THE ODOUR UNIT PTY LTD

3 September 2010

NO FUSS WASTEWATER TREATMENT FACILITY – ODOUR ASSESSMENT

Figure 2a: Site plan for Unit 2/ 10-12 Smith St, Emu Plains

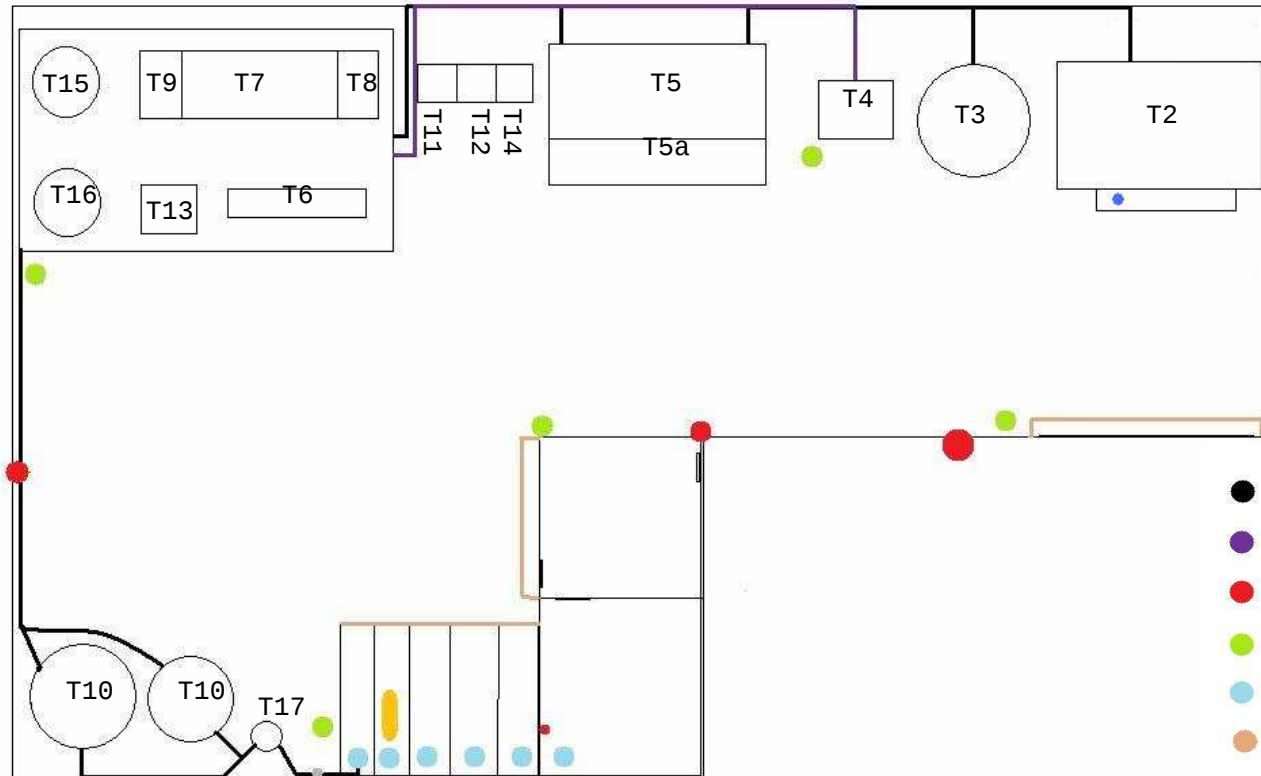
These operations will take place in the room at the rear of the factory. No ventilation of the room is proposed. Truck access to the room is via a standard roller shutter door adjacent to the Holding Tank. It is proposed to keep this door closed, except when receiving oily wastewater. It was noted that the construction of the factory has not involved the sealing of the roof/wall joints, in keeping with normal factory design. The resulting gap will provide an opening through which air from inside the room could be drawn to atmosphere, under certain conditions, including thermal buoyancy effects and wind-induced negative pressures on the outer downwind face of a wall.

While all of the above treatment tanks will generate odour to some extent, the bulk of the odour releases into the room will emanate from the Holding Tank (particularly during filling), the Oily Water Separator, the Storage Tank and DAF unit, and the Sludge Tank. Generally more odour is generated at the front end of a treatment process, particularly where the waste material has an exposure to the atmosphere. For this reason storage and sludge tanks emit less odour than expected, due to a relatively small exposed surface area. The covering of these tanks is recommended.

The Holding Tank, and the pit beneath it, is considered to be the major odour source. The proximity of this source to the roller door is potentially problematical, and could result in short term odour emissions if the door remains open during

waste unloading. The design of the Holding tank and pit does not lend itself to full enclosure and capture of a foul air stream for possible treatment. Similarly, the open design of the DAF renders the enclosure and air capture difficult.

On the basis of the information provided to TOU and observations made during the site visit it is considered that odours generated during the operation of the proposed oily water treatment plant can be managed by a combination of good management practices and the sealing of the treatment room. Management practices should include:

- Minimising odour generation by operation of the treatment plant at optimal conditions;
- Keeping all doors closed, except for short periods when needed; and
- Possible use of odour neutralising products with proven performance in the oily water industry

The sealing of the room should result in the closure of all roof/wall interface gaps. Styrene foam has been used successfully by other TOU clients, for this purpose. If odour emissions from the opening of the roller door be found to be problematical consideration could be given to extending the building to enclose the truck unloading area.
